REQUEST

SUMMARY OF PETITION

The petition proposes to allow expansion of a parking area to support uses permitted in the MUDD district in the adaptive reuse of a building in the Enderly Park neighborhood.

PLANNING STAFF REVIEW

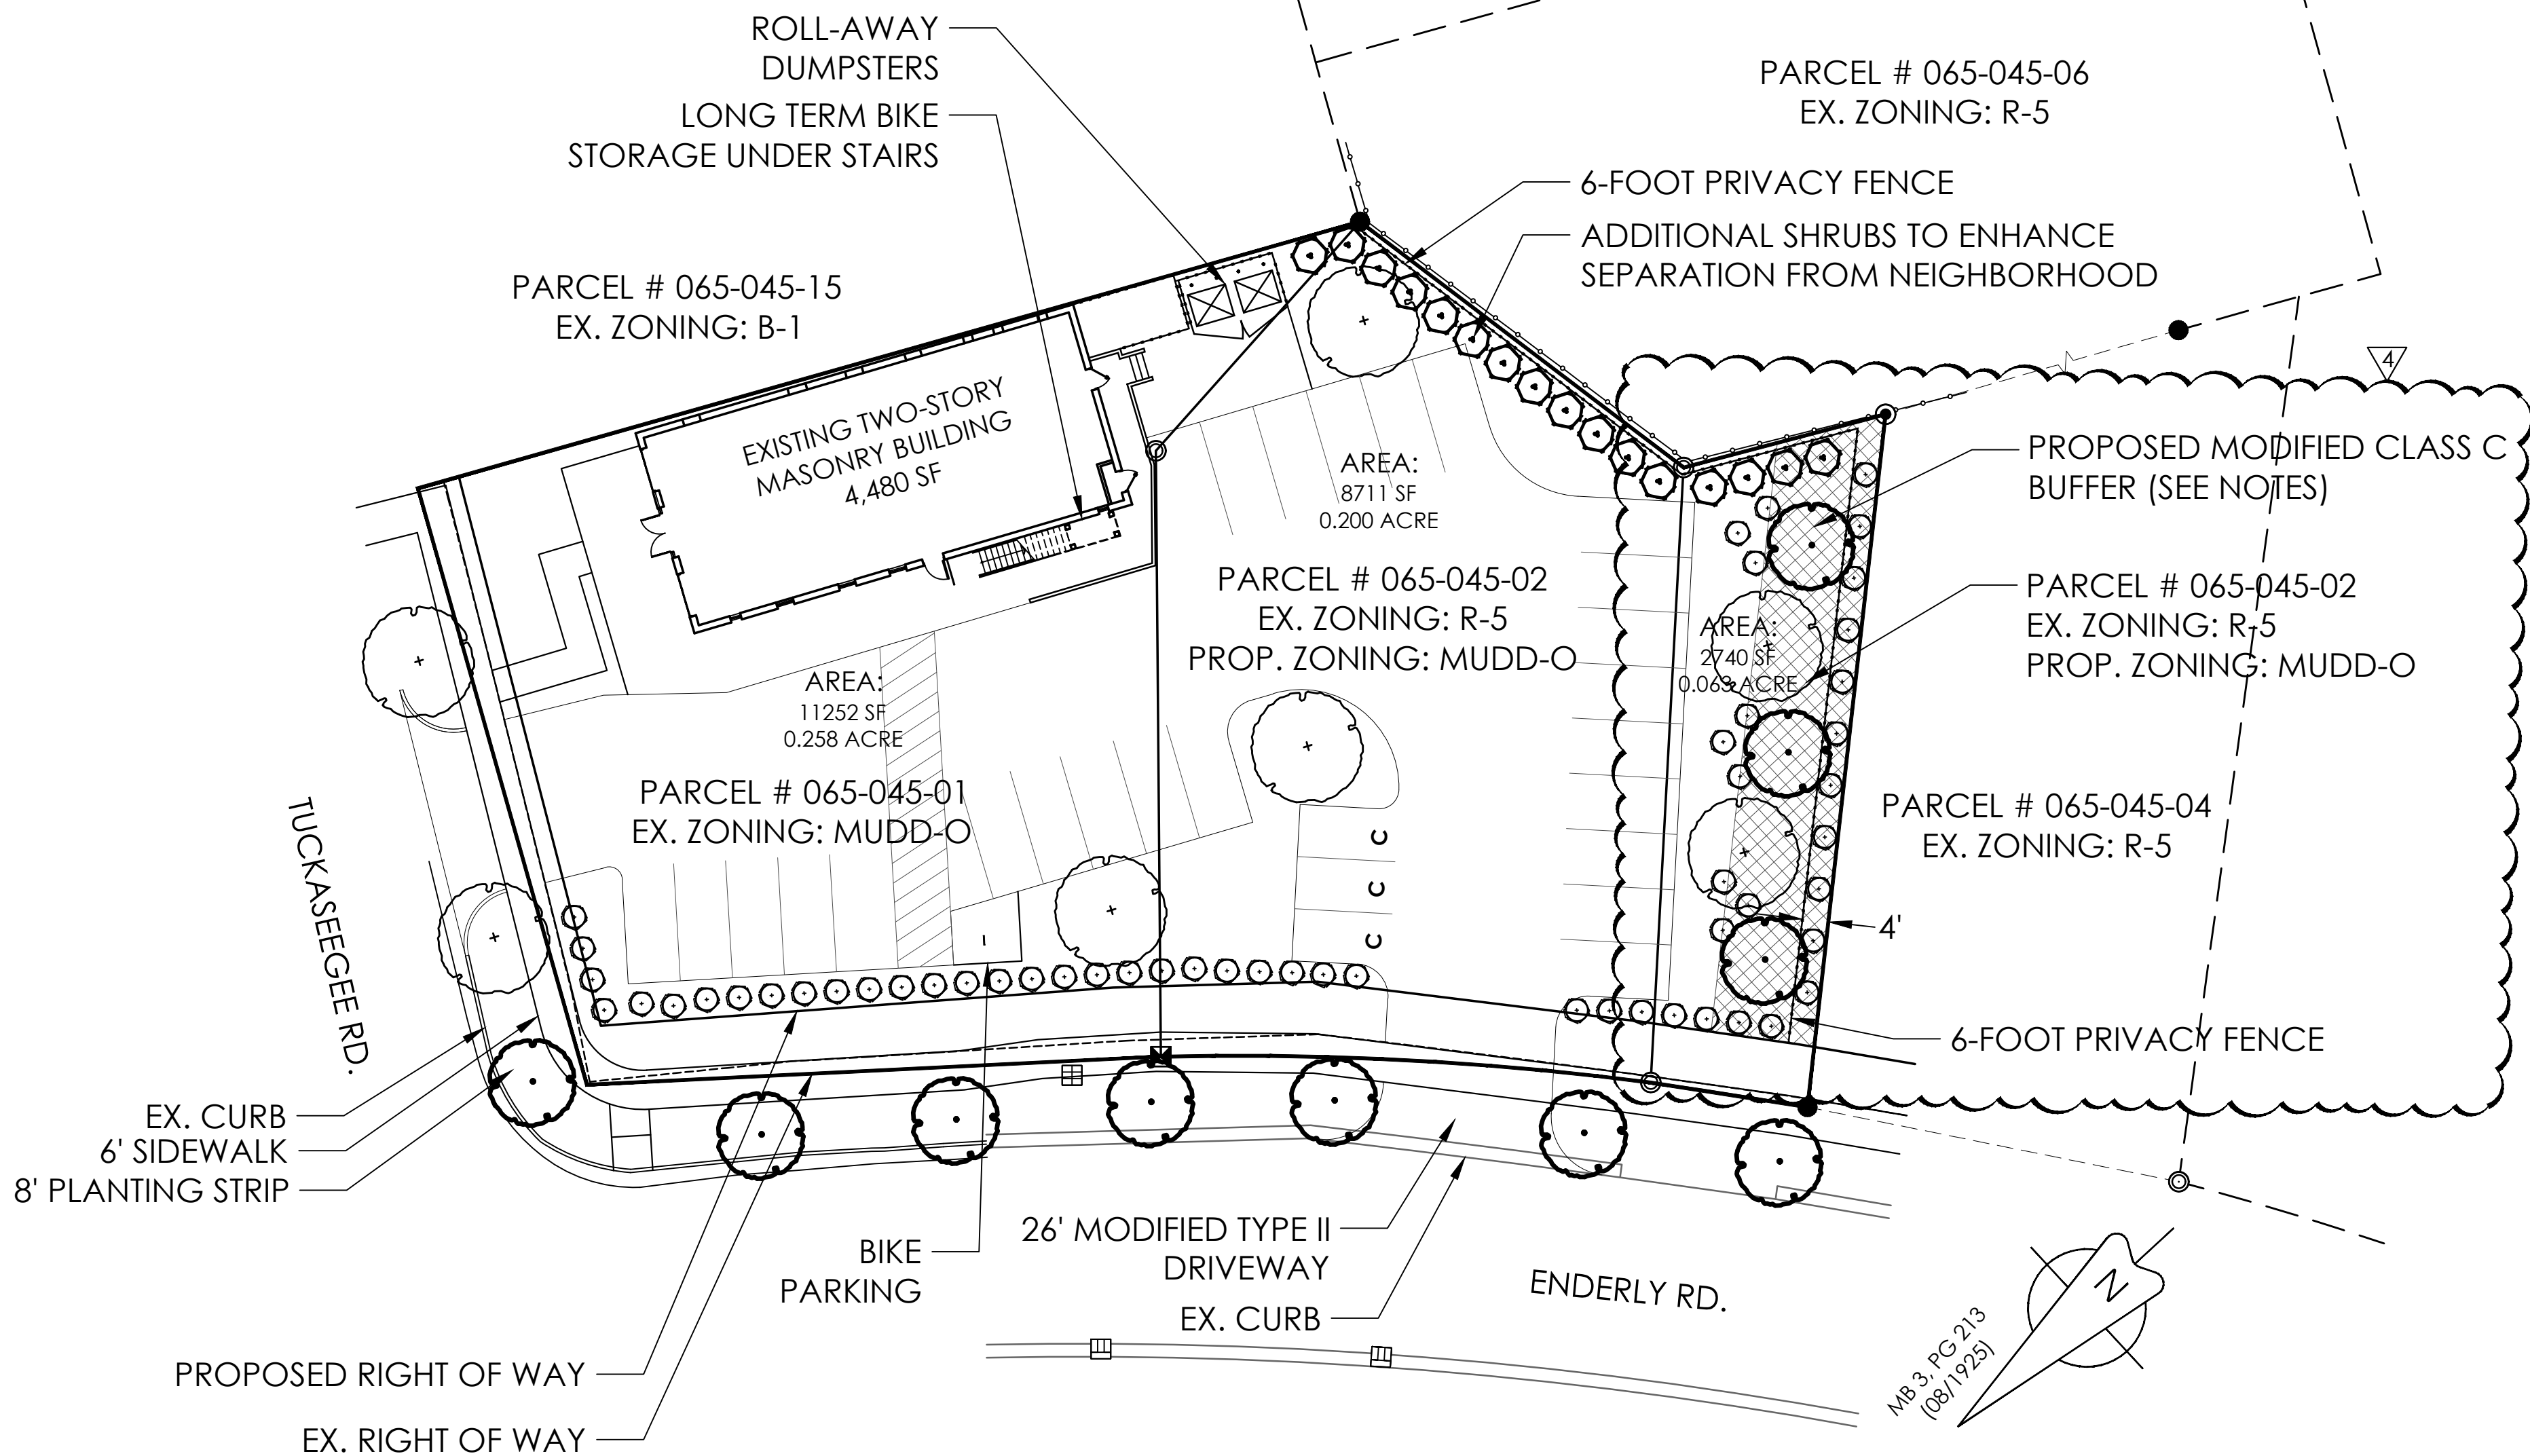
- ~~1. Add a conditional note stating that the existing two-story commercial structure will remain and not be expanded and that no other building may be constructed.~~ **ADDRESSED**
- ~~2. Clarify that note 2 under Optional Provisions applies only to the existing two-story commercial structure.~~ **ADDRESSED**
- ~~3. Remove note 3 under Optional Provisions.~~ **ADDRESSED**
